Our Ref: TR010029

Date: 25 June 2020

Application by Highways England for an Order Granting Development Consent for the M25 junction 28 Improvements

Procedural Decision following issue of Acceptance decision

Project Title	M25 junction 28 improvement scheme
Drawing Title	Figure 9.40 – Viewpoint B (Grove Farm) opening year photo-montage (winter) left and right split (2 Sheets)

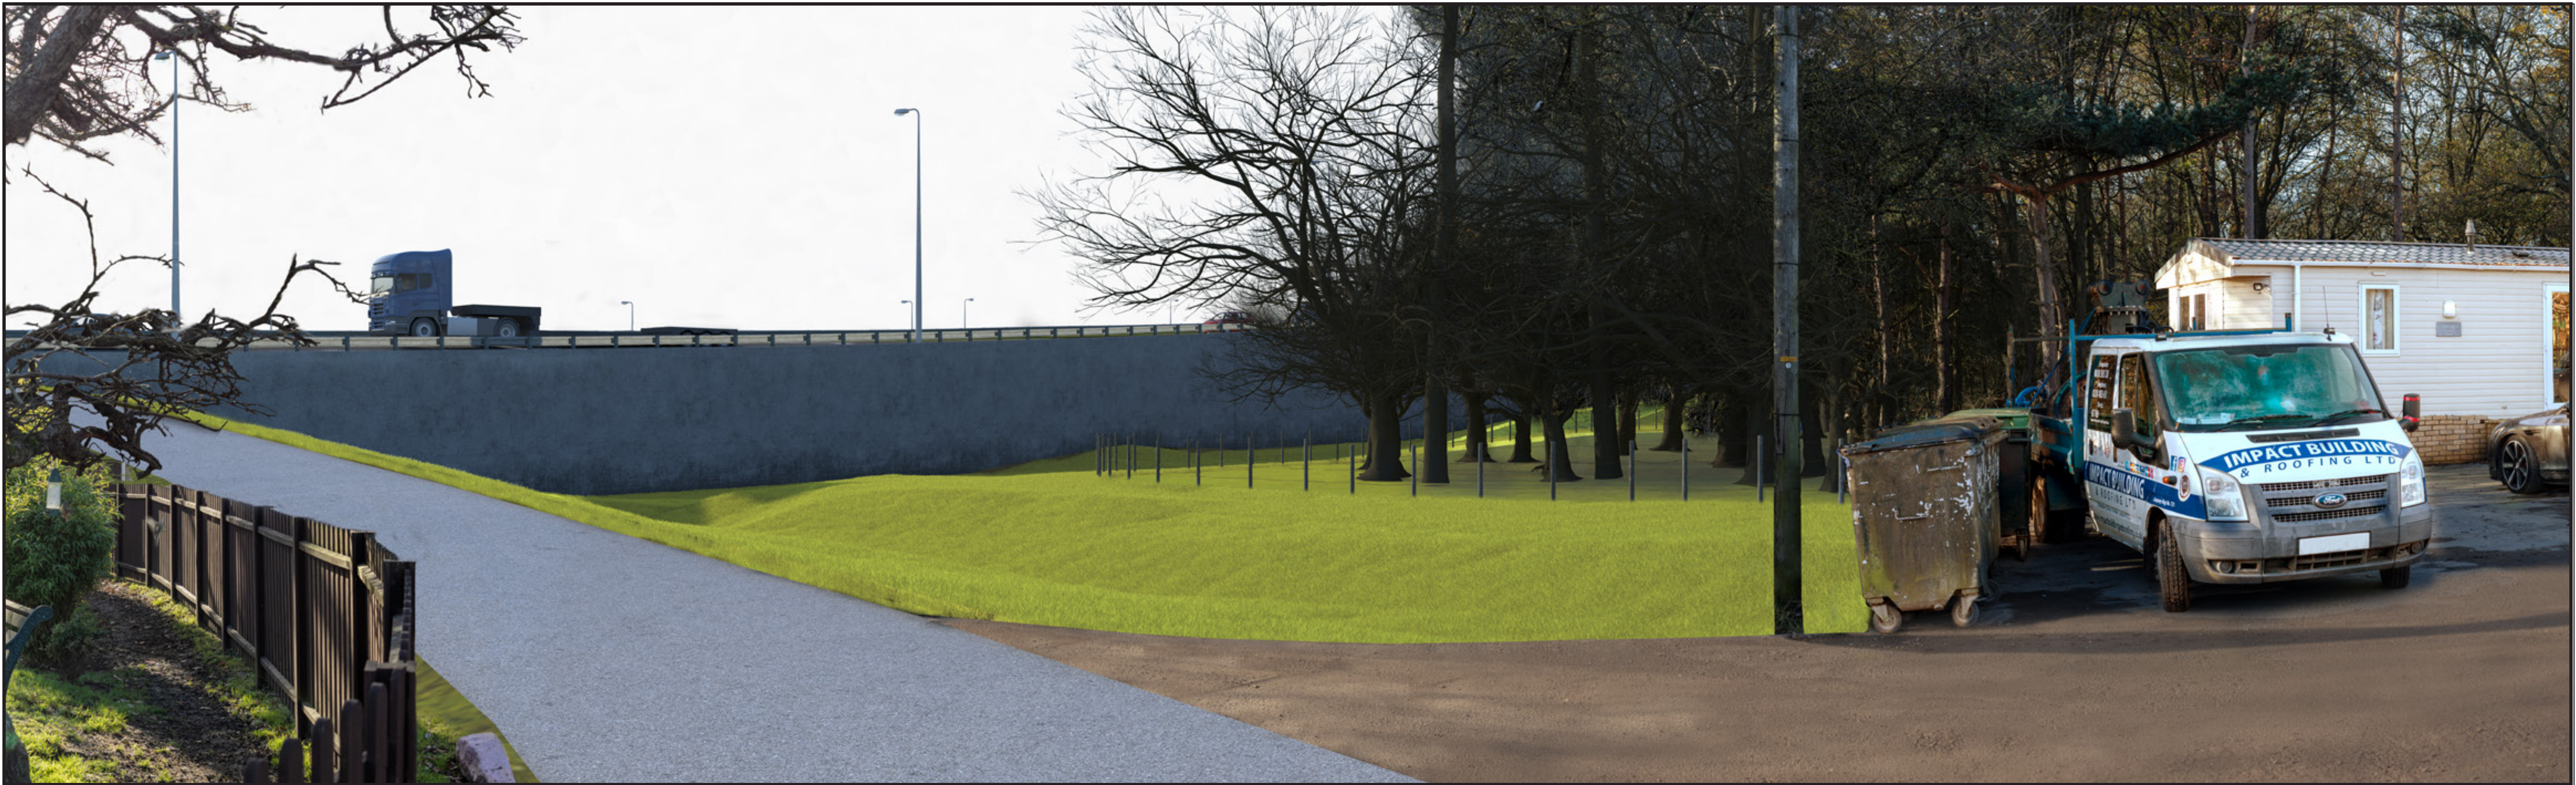
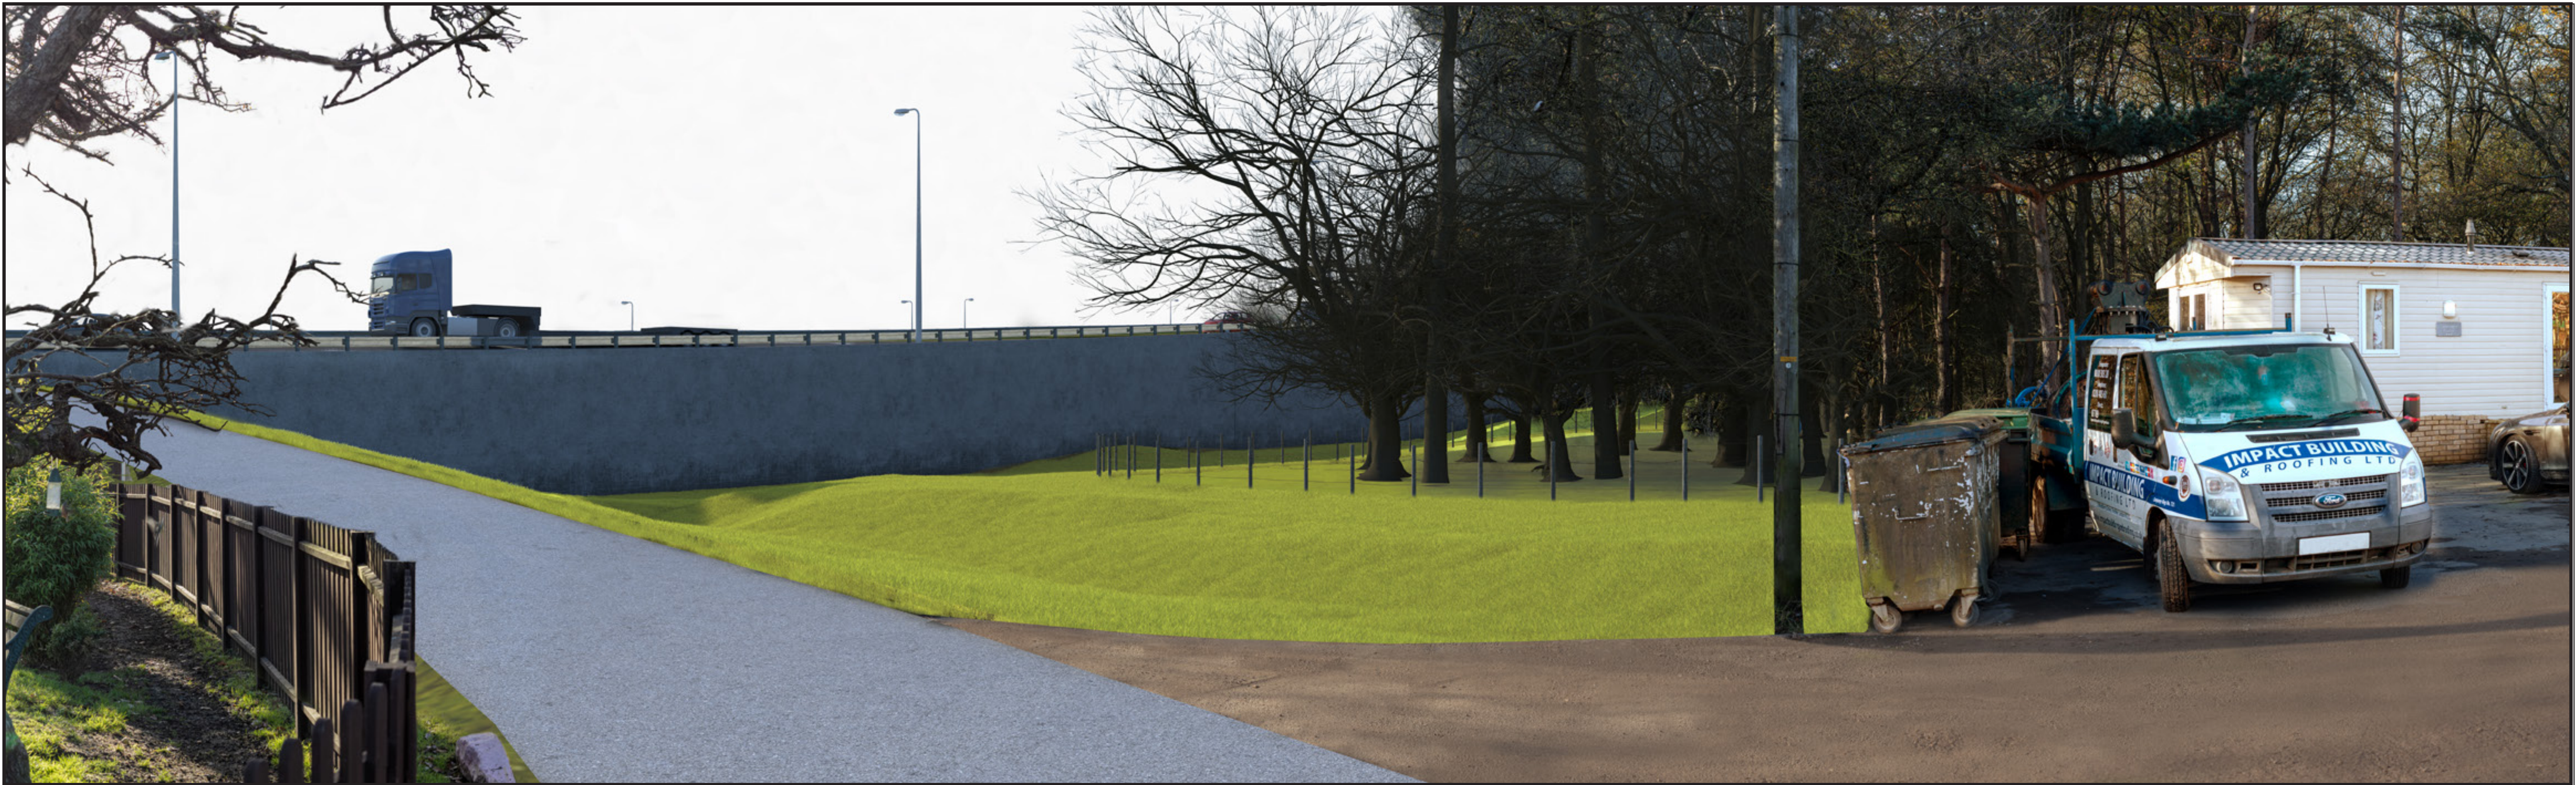
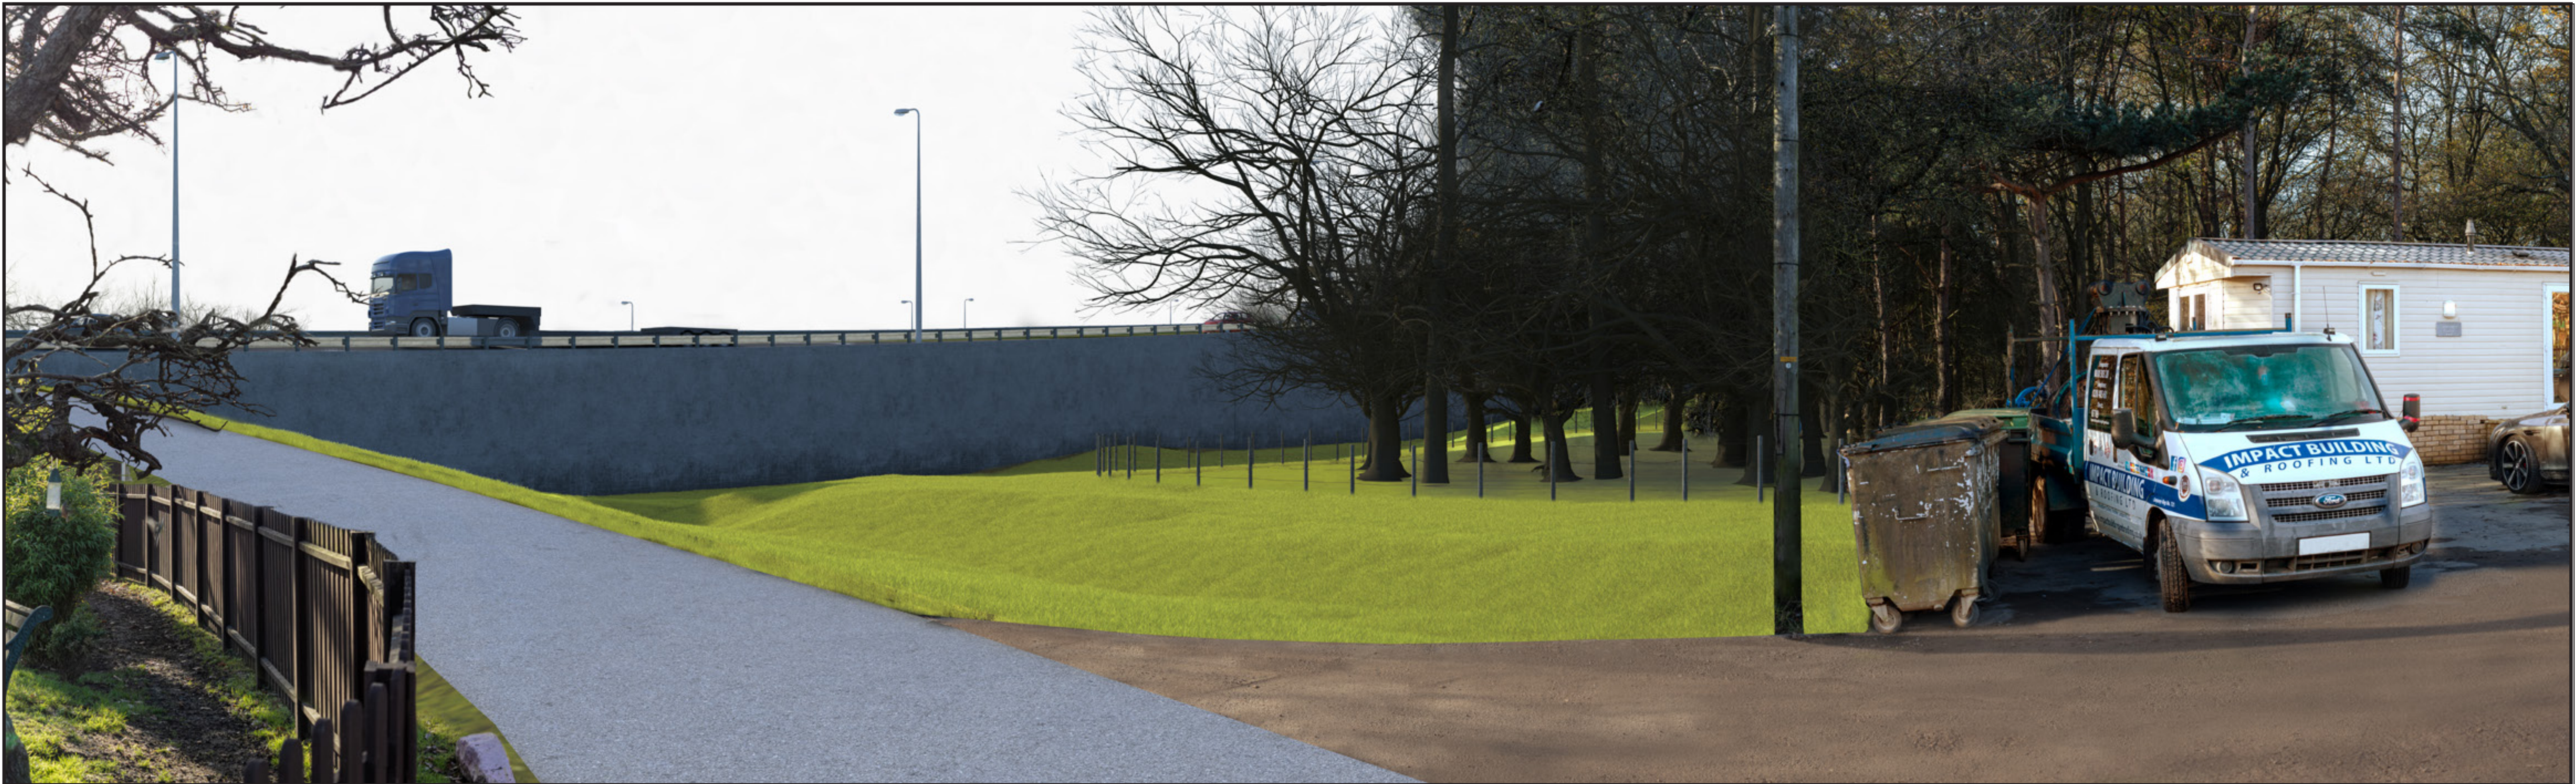
The Landscape and Visual Impact Assessment within the Environmental Statement (ES) states that photomontages depicting the Proposed Development in context to chosen viewpoints are not necessary to inform the assessment of likely significant effects. The ES states that this is an approach agreed with relevant consultation bodies although no specific evidence confirming or refuting this position is provided. Notwithstanding this and having regard to the characteristics of the Proposed Development, I consider that photomontages would facilitate an effective examination. The photomontages should be relevant to the existing agreed

viewpoints but should also depict key structures and design features of the Proposed Development including but not limited to, major earthwork proposals (embankments) and the proposed realignment of the River Ingrebourne and Weald Brook. The Applicant should make efforts to ensure that photomontages are produced to a standard recognised and advocated by relevant professional institutes eg the Landscape Institute.
